REQUEST

Current Zoning: N1-B (Neighborhood 1)
Proposed Zoning: UR-2(CD) (Urban Residential, Conditional)

Approximately 2.73 acres located east of S Tryon Street, south of Nations Ford Road, and north of Skipwith Place.

The petition proposes to allow 33 single family attached dwelling units on a vacant property on S Tryon Street.

RZ-1

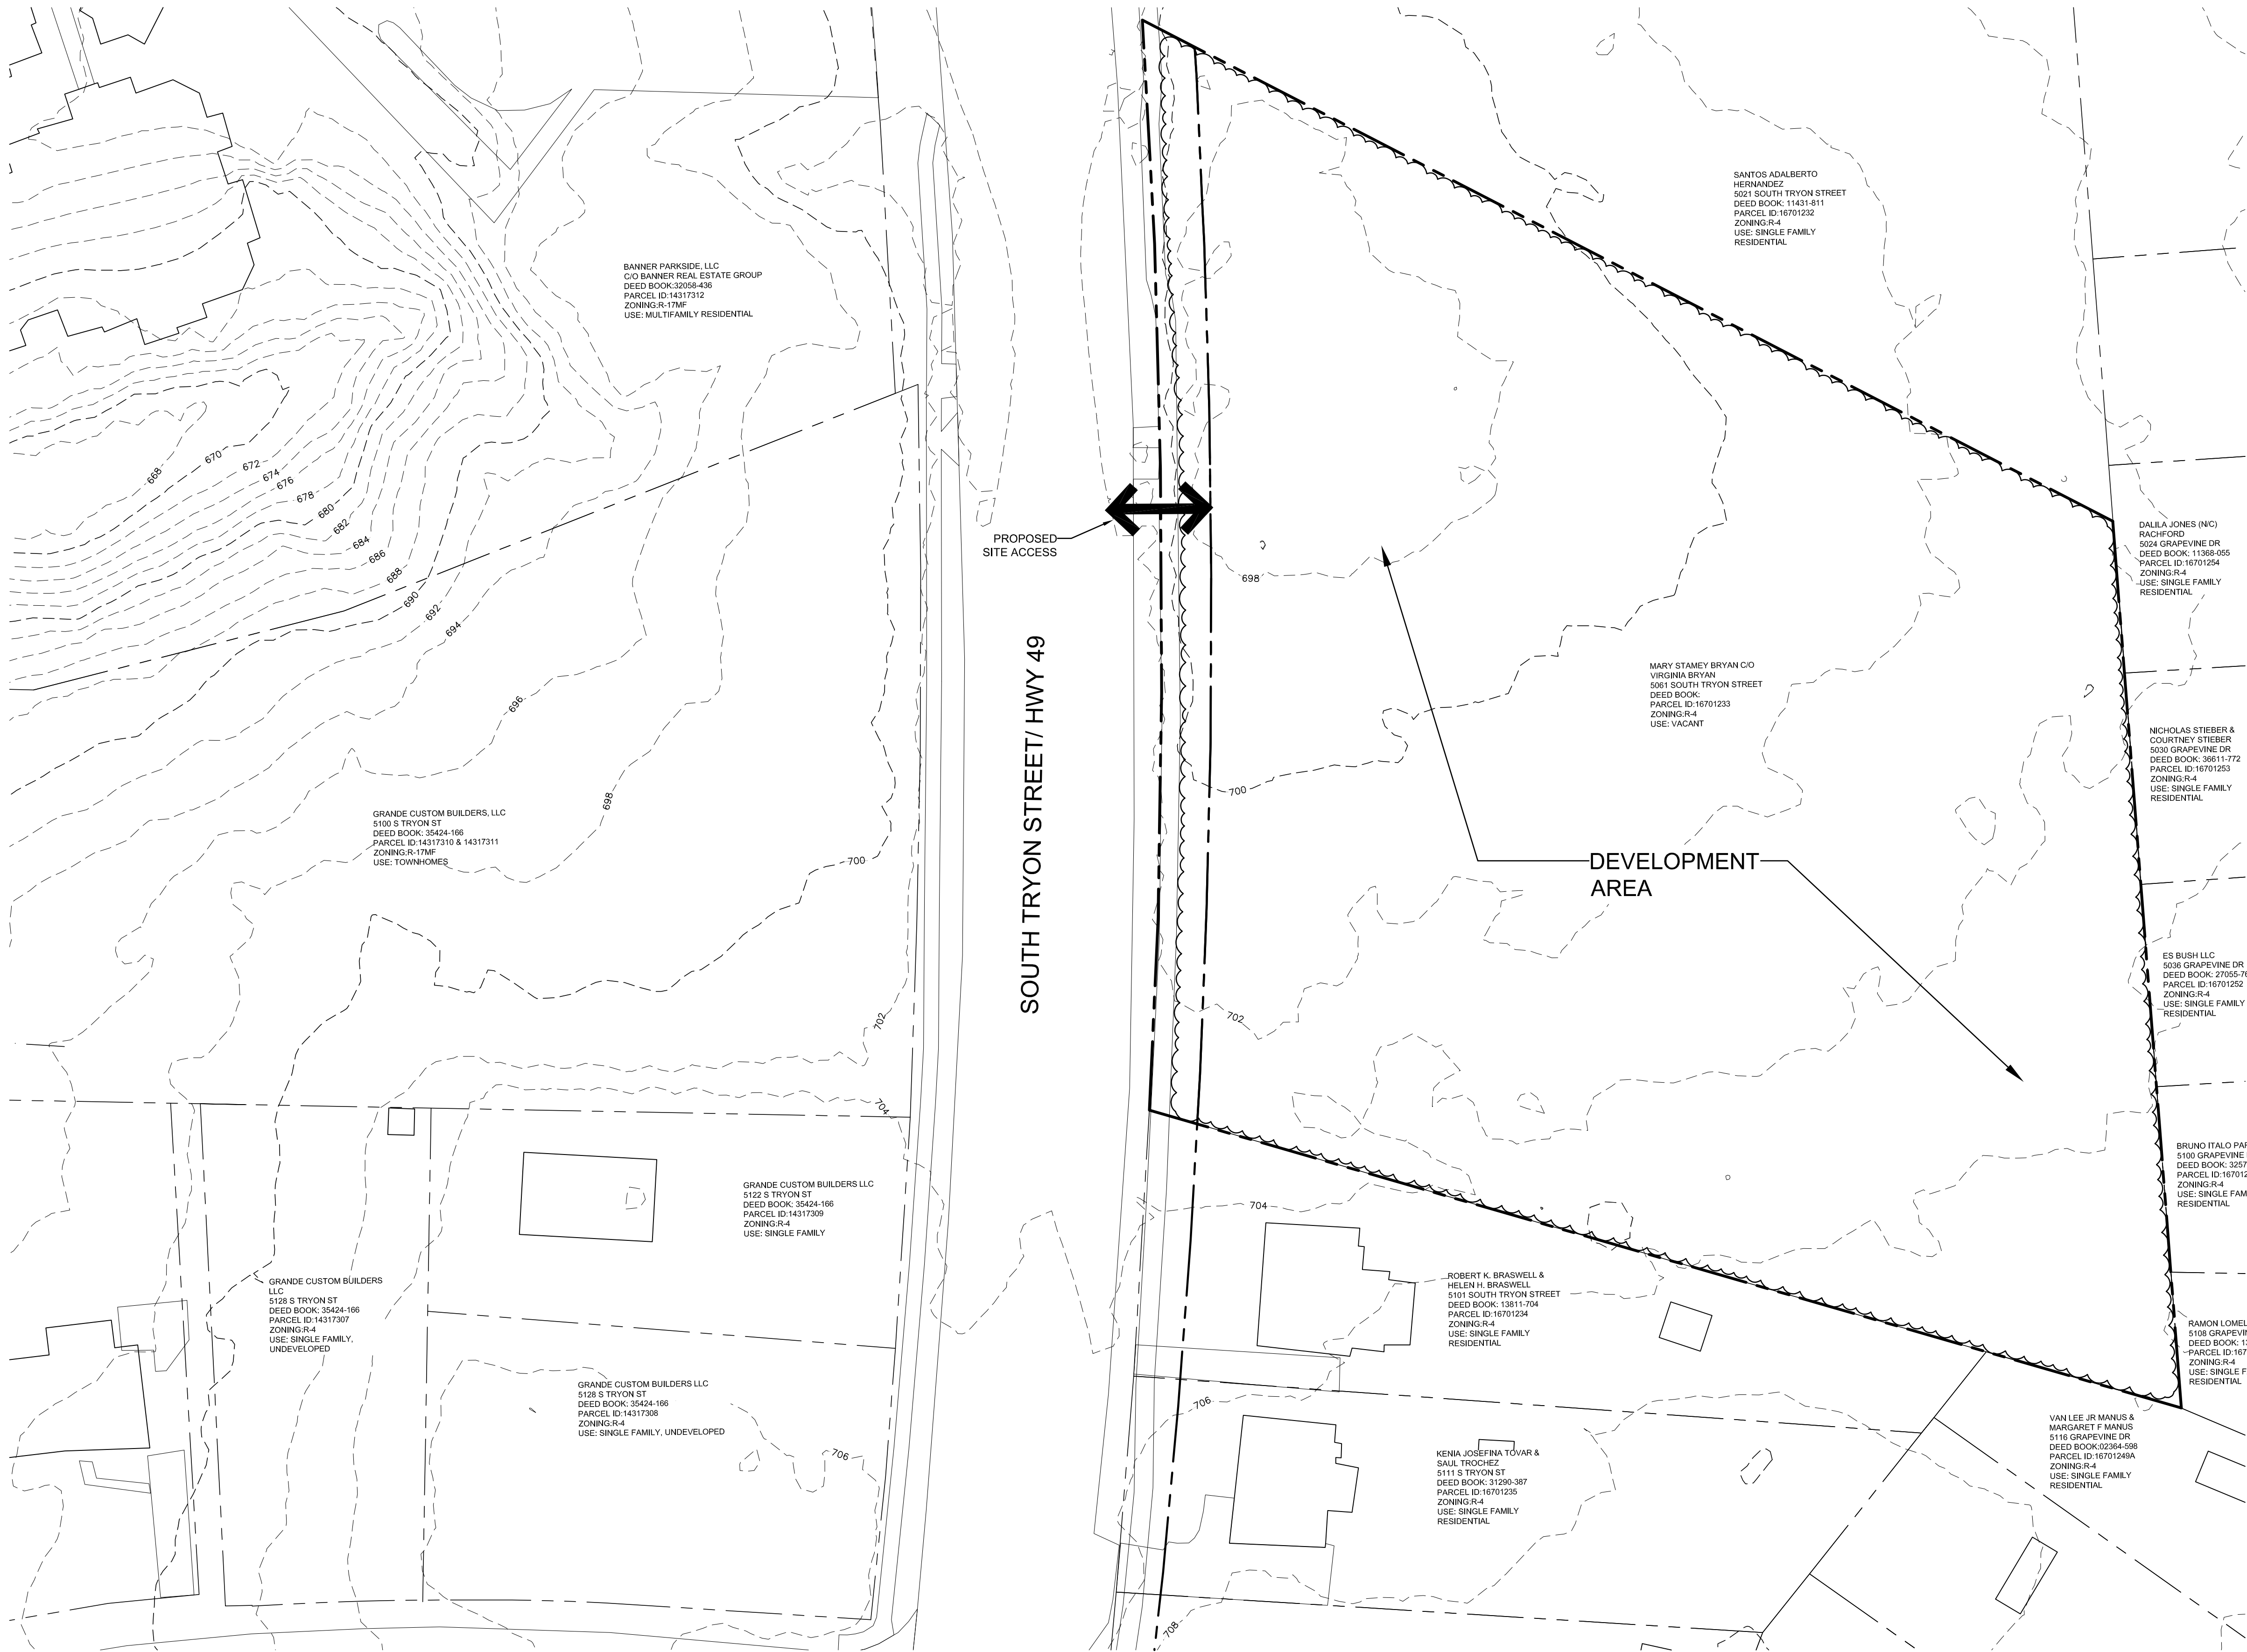
- ~~2. Increase minimum setback of S Tryon Street to 20 feet.~~ **ADDRESSED**

- Establishes a 27' setback from future back of curb.
- Commits to the following transportation improvements:
 - Dedicates 61' of right of way from the centerline of S Tryon Street.

- ~~1. Remove the following language from note C.8: "required to be constructed by petitioner under this section C of the development standards."~~ **ADDRESSED**
